Date: 1-8-11

From: Roger Evans

Subject: Comments Former Cereal Partners site – Broadwater Road

BROADWATER ROAD WEST, WELWYN GARDEN CITY
 DETAILED PROPOSALS: ENERGY CENTRE
 PROPOSED GENERAL ARRANGEMENTS
 568_07_165
 SCALE: 1:100 @A0 1:200 @A2

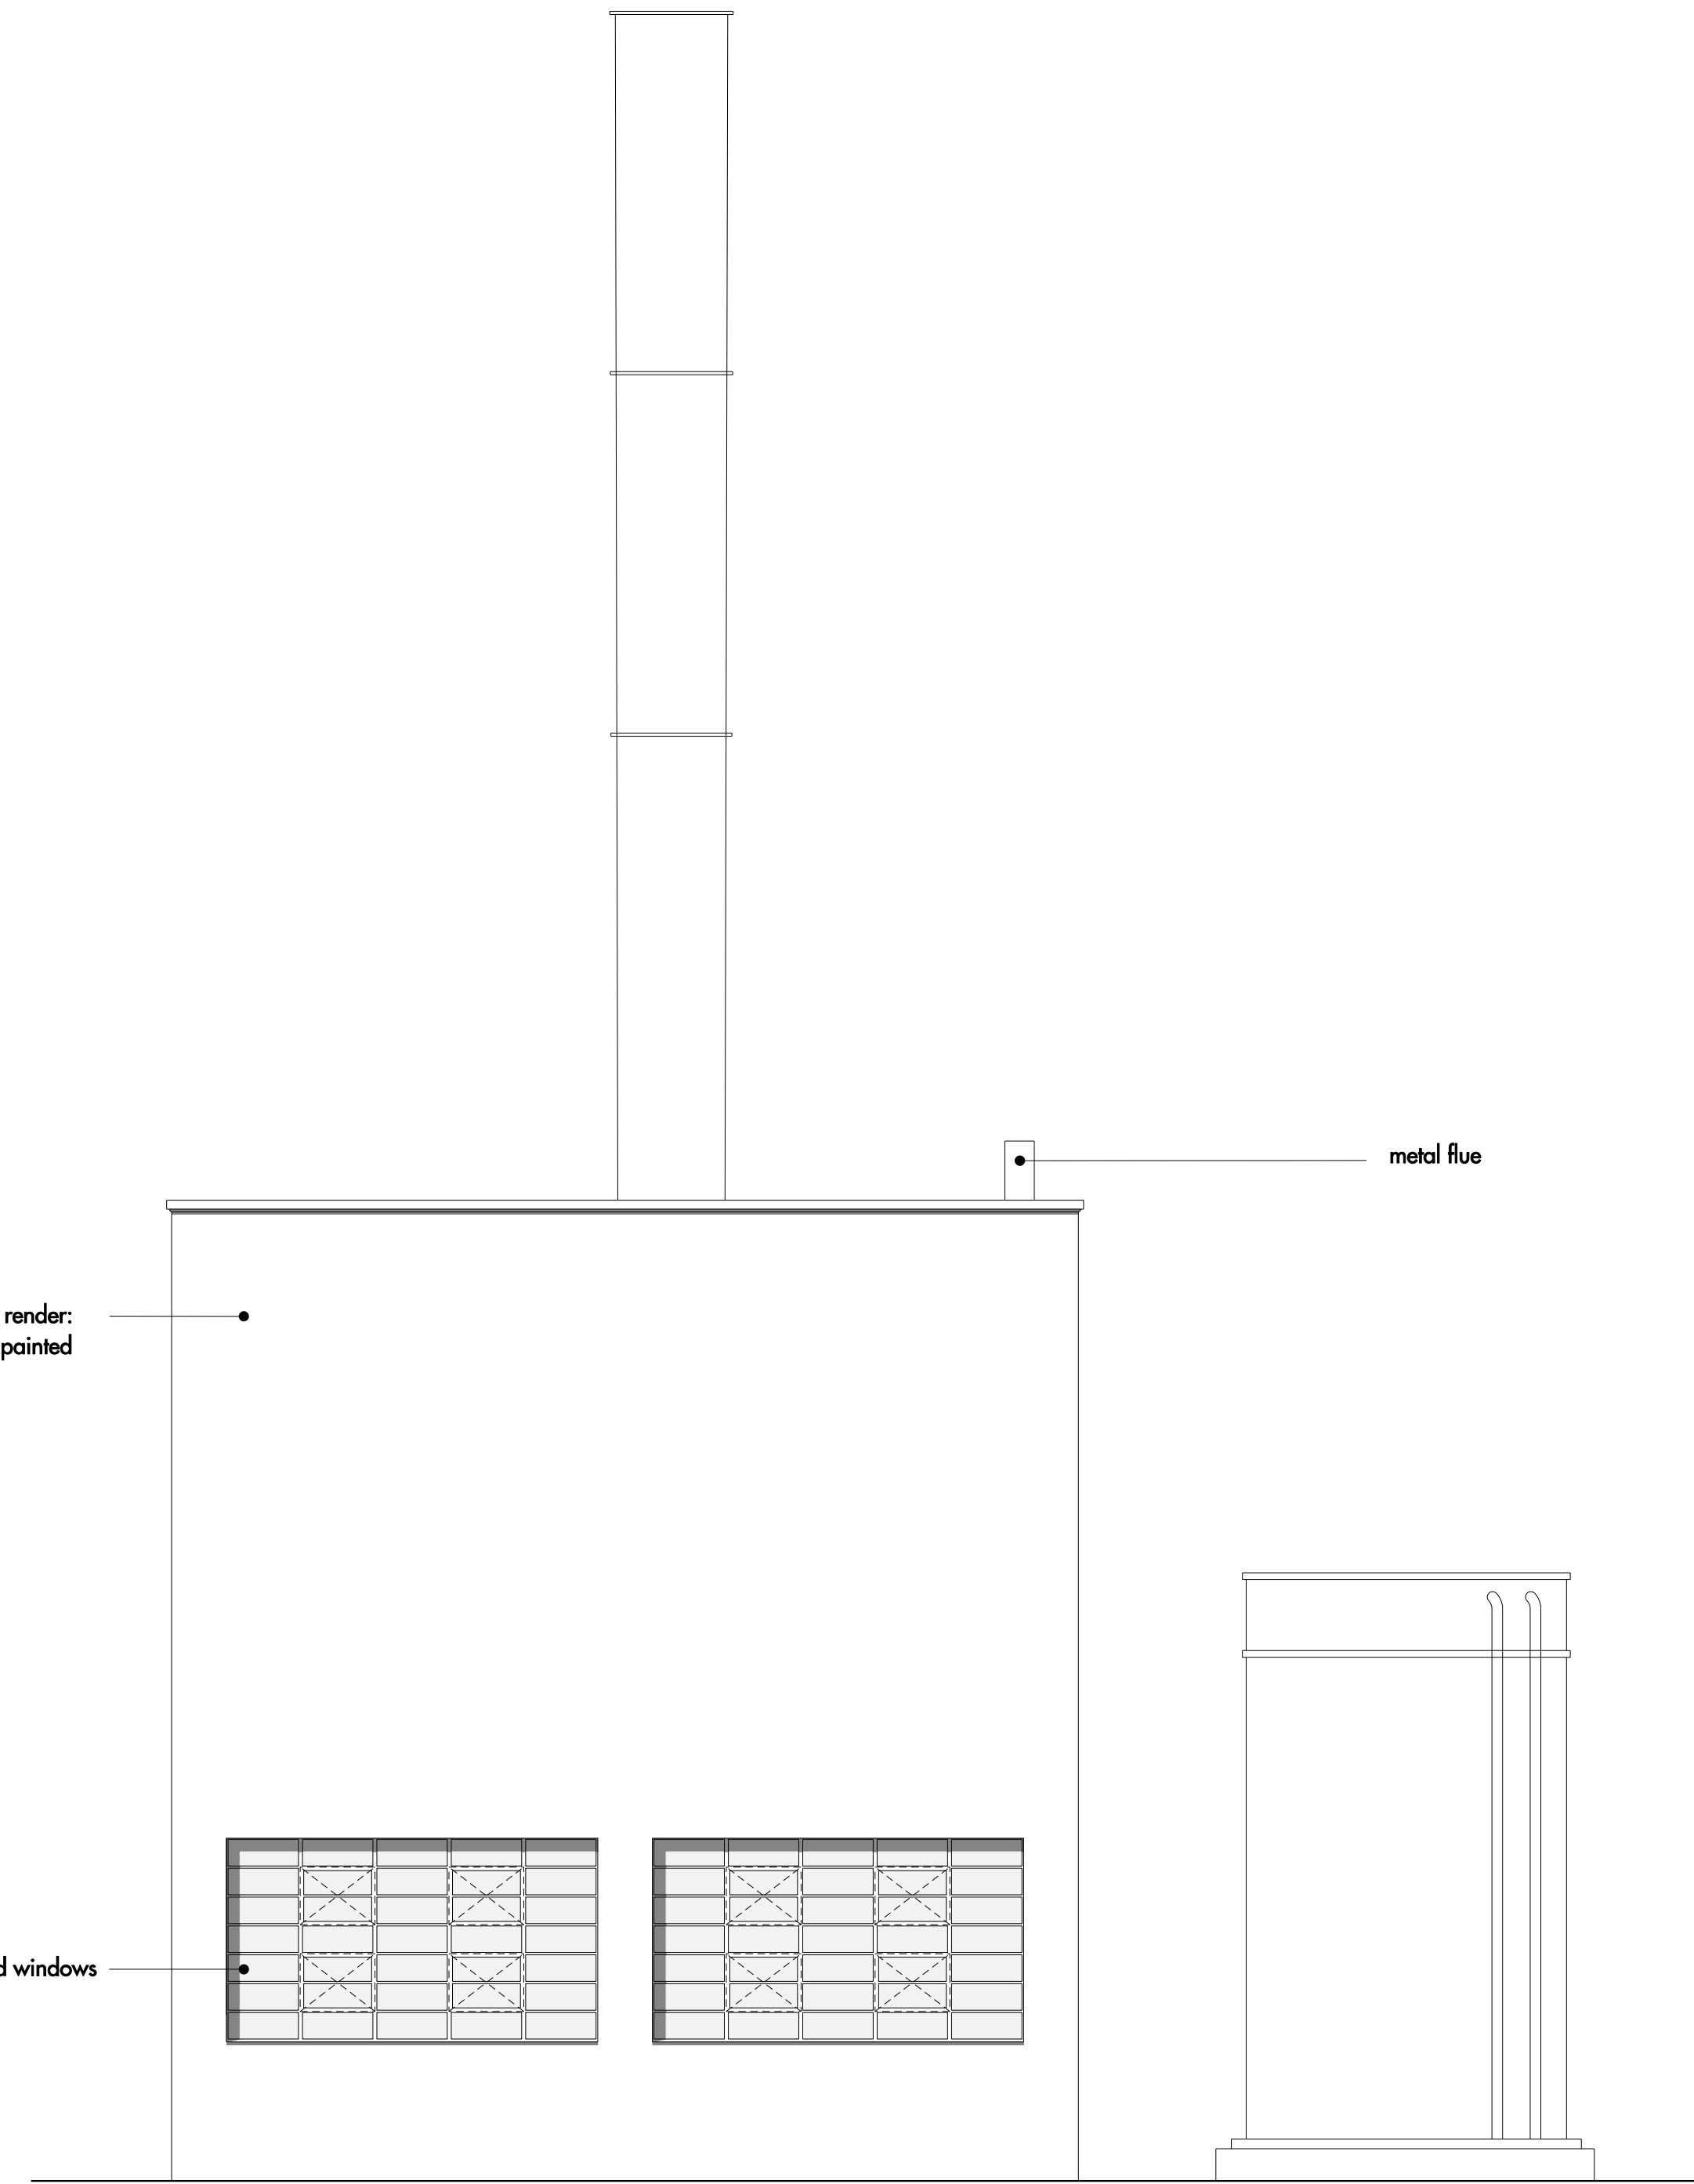
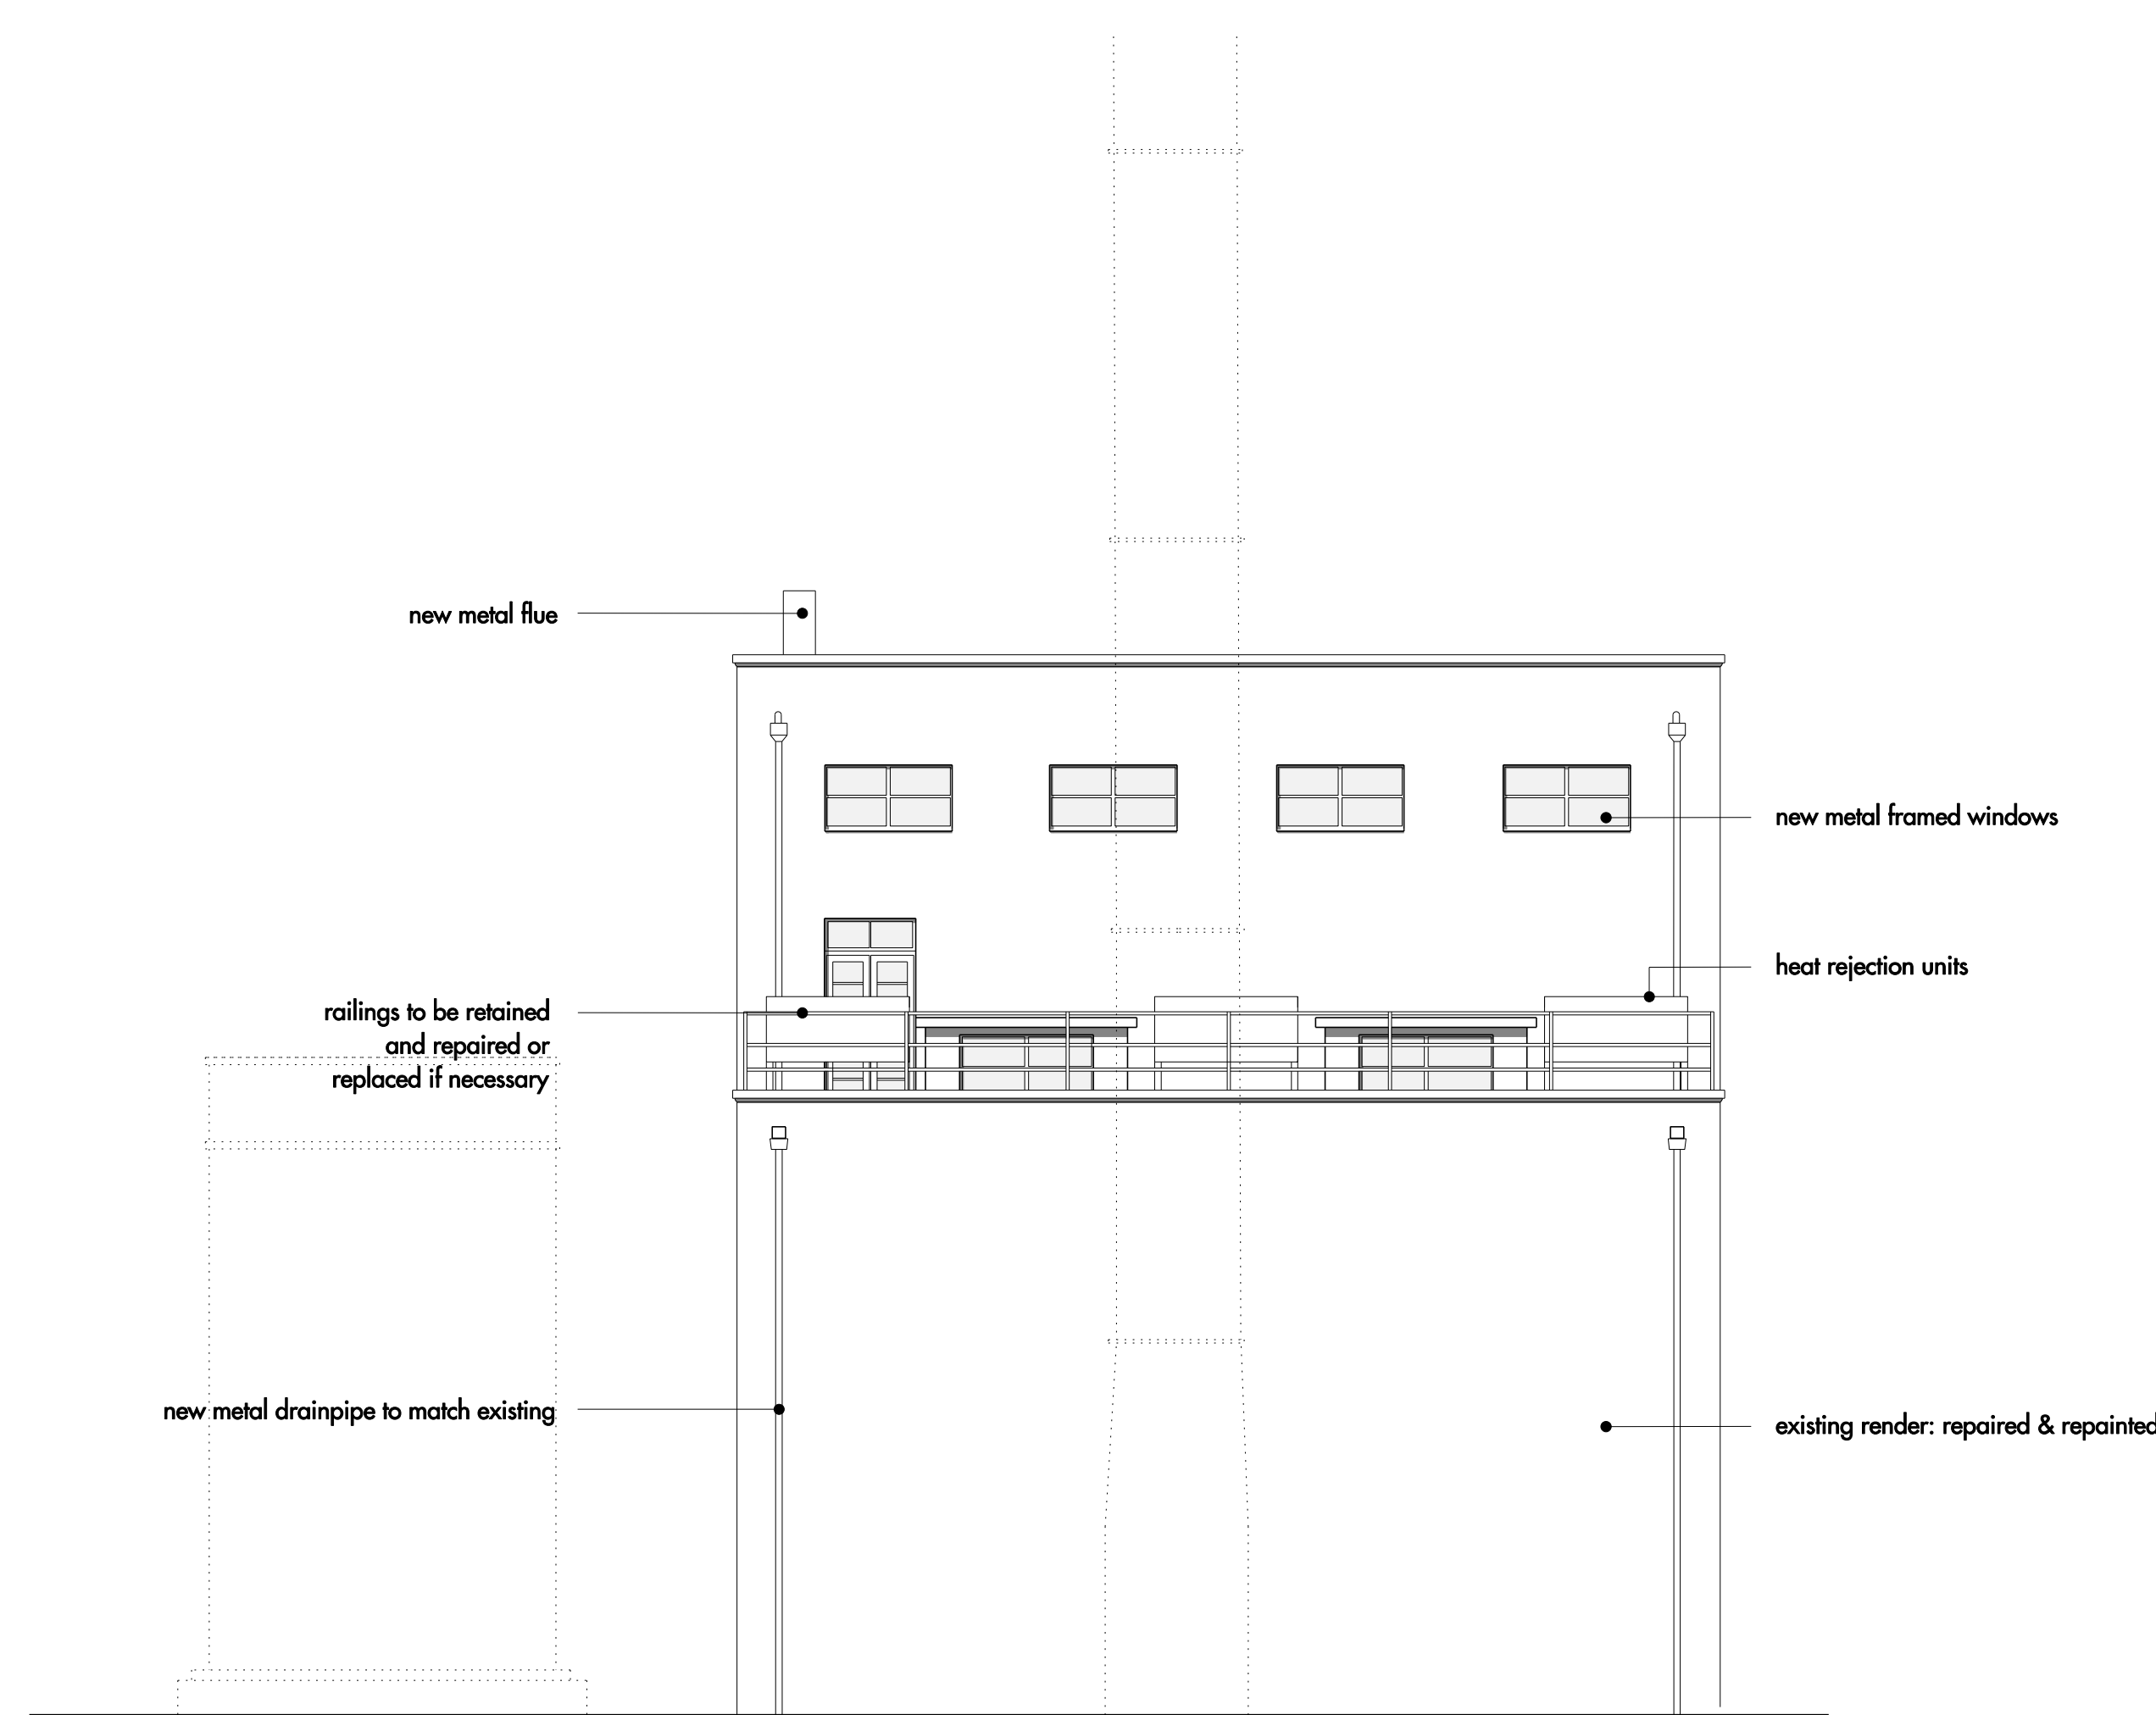
The assessment of noise from the CHP indicates that the “target” maximum noise level is 33 dBA at 10m from the building is achievable, based on information from the potential supplier. For this to be possible the two external heat rejection units will have to be “low noise” models capable of a maximum noise output of 30 dBA at 10m (consequently a combined level of 33dBA) . In addition the attenuation provided behind the louvers and to ventilation duct openings would need to be able to reduce the noise level from the remaining plant to 20dBA at 10m. *The combined total would not in this case exceed the 33dBA level required.* The output from the heat rejection units will be readily available, details of the performance of equipment to attenuate the louvers and the ventilation ducts will need to be provided .

Insofar as conditions are concerned I would suggest – A scheme of attenuation for the CHP should be submitted and agreed by the planning authority. This should indicate plant noise levels, including frequency analysis, and the attenuation details in respect of internal and external plant, calculated to ensure the noise level at 10m from the building, relating to the CHP operation, does not exceed 33dBA.
